DRB Project Number: 1011486
Perea Addition

SUBJECT: Preliminary/ Final Plat

Application #: 18DRB-70102

# A.L.T.A./A.C.S.M. LAND TITLE SURVEY

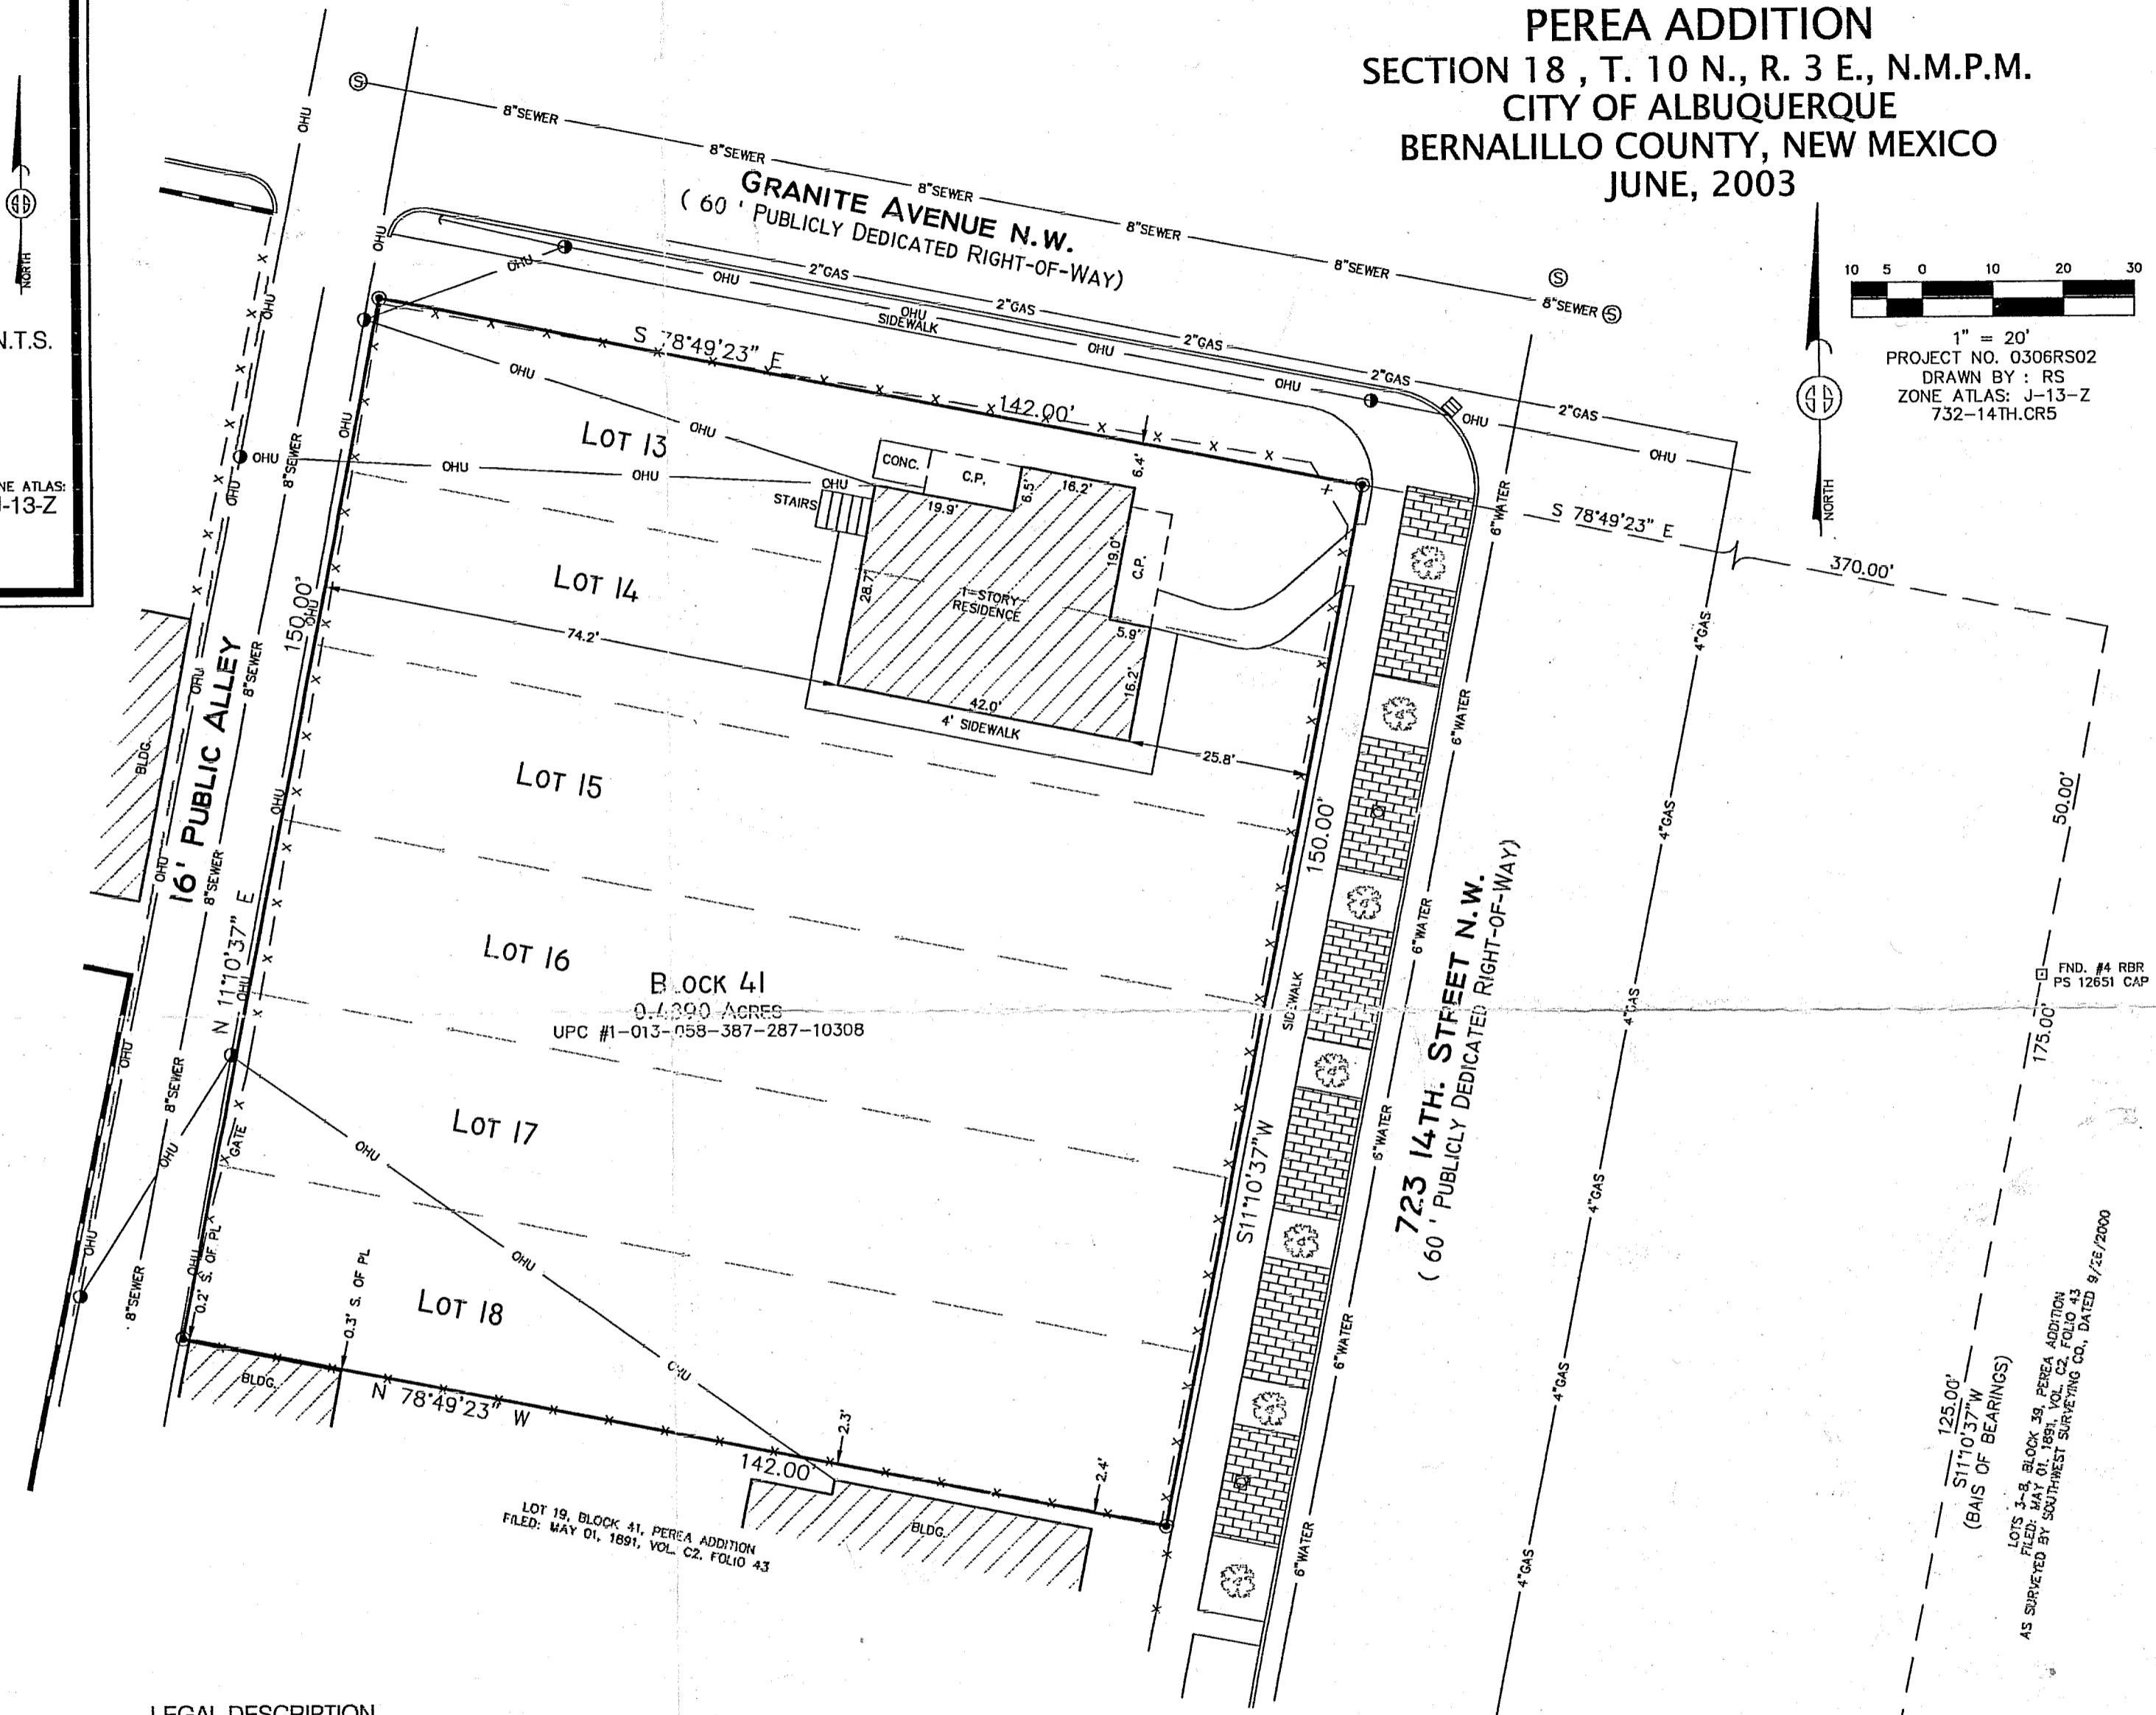
- No adverse comments to the platting action – see Code Enforcement comments
- Try to save as many trees as possible on the site. Trees along 14th street should remain since there will not be any curb cuts. Access is off the alley.

The property is Zoned SU-2/DNA-SF and the Minimum Lot Area is required to be 5,000 square feet. Based on a lot width of 33.25ft by a lot depth of 142ft the lots are only 4,721.5ft in size. A variance would need to be acquired for the lot size adjustment.
